Rezoning Transportation Analysis

Petition Number: 2020-161

General Location Identifier: Tax ID 03327114

From: Robyn Byers, Ph.D.
Robyn.Byers@charlottenc.gov
704-336-7404

**THE HUMAN BEAN**  
**LONG CREEK VILLAGE**  
**CHARLOTTE, NC**  
**ZONING EXHIBIT**

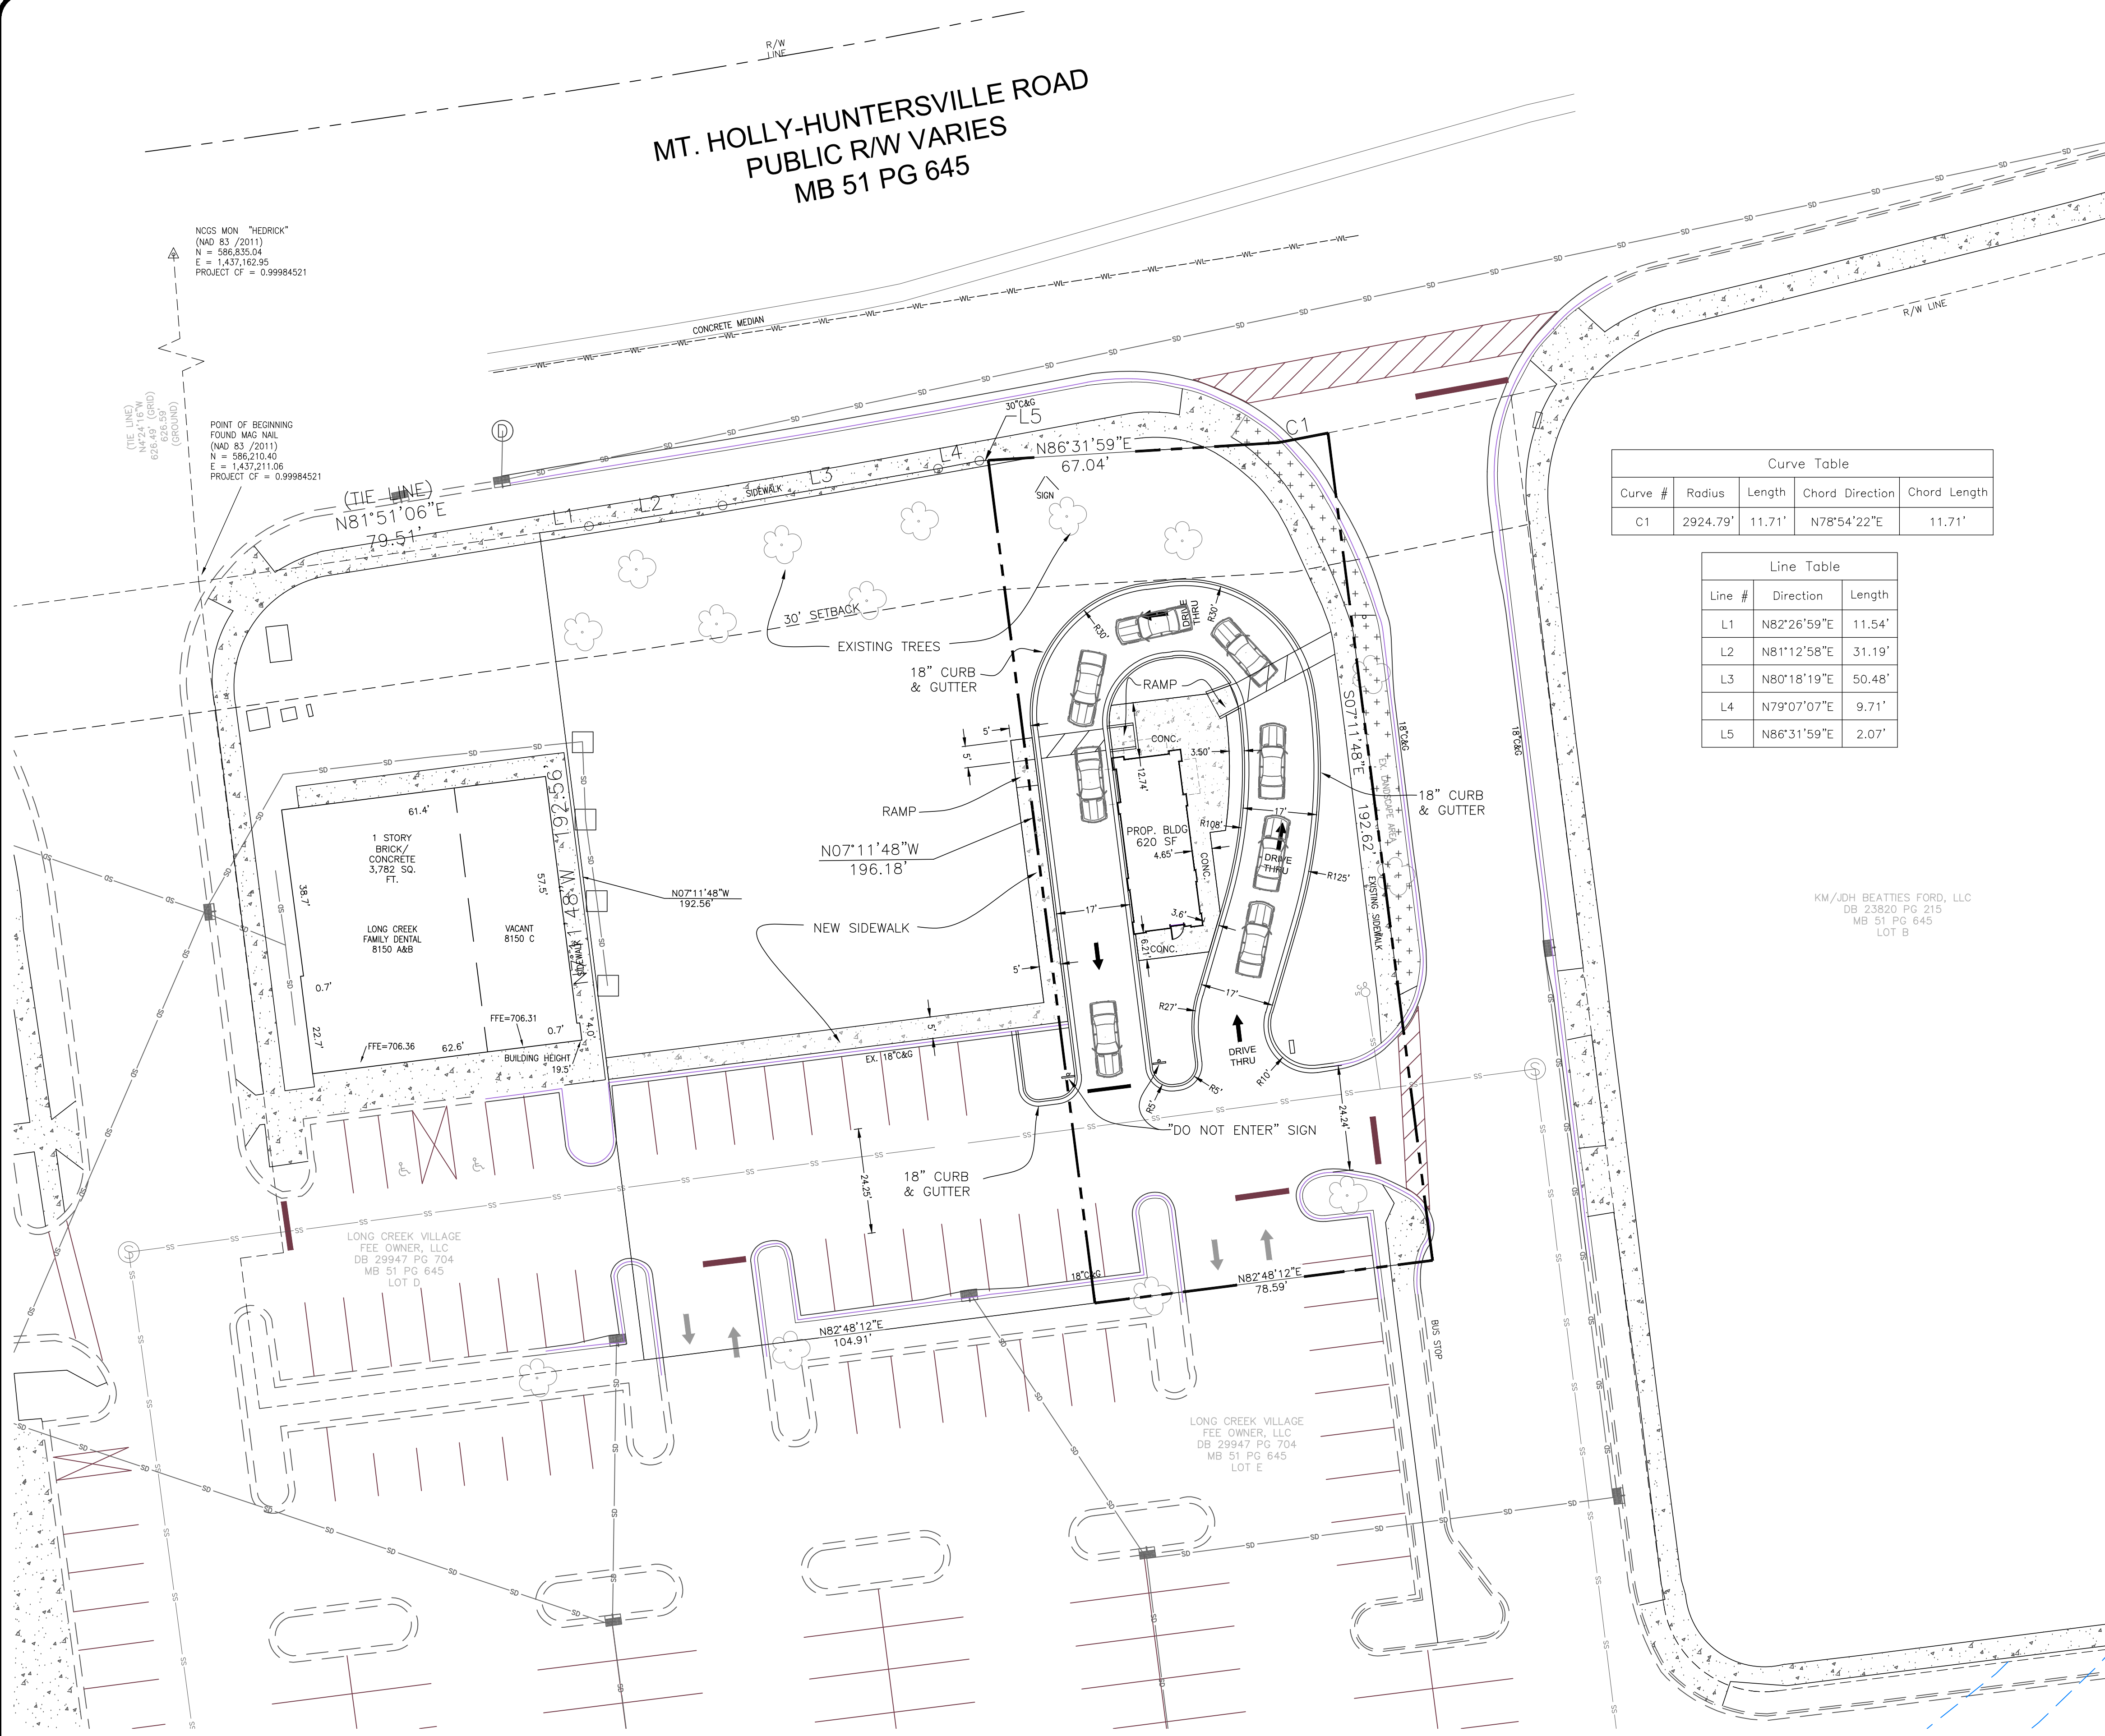
7. **Technical Clarification** (site plan dated 1-10-21) Revise the site plan and conditional note (Section Transportation.E.) to dedicate public right-of-way or a sidewalk utility easement at the location below.
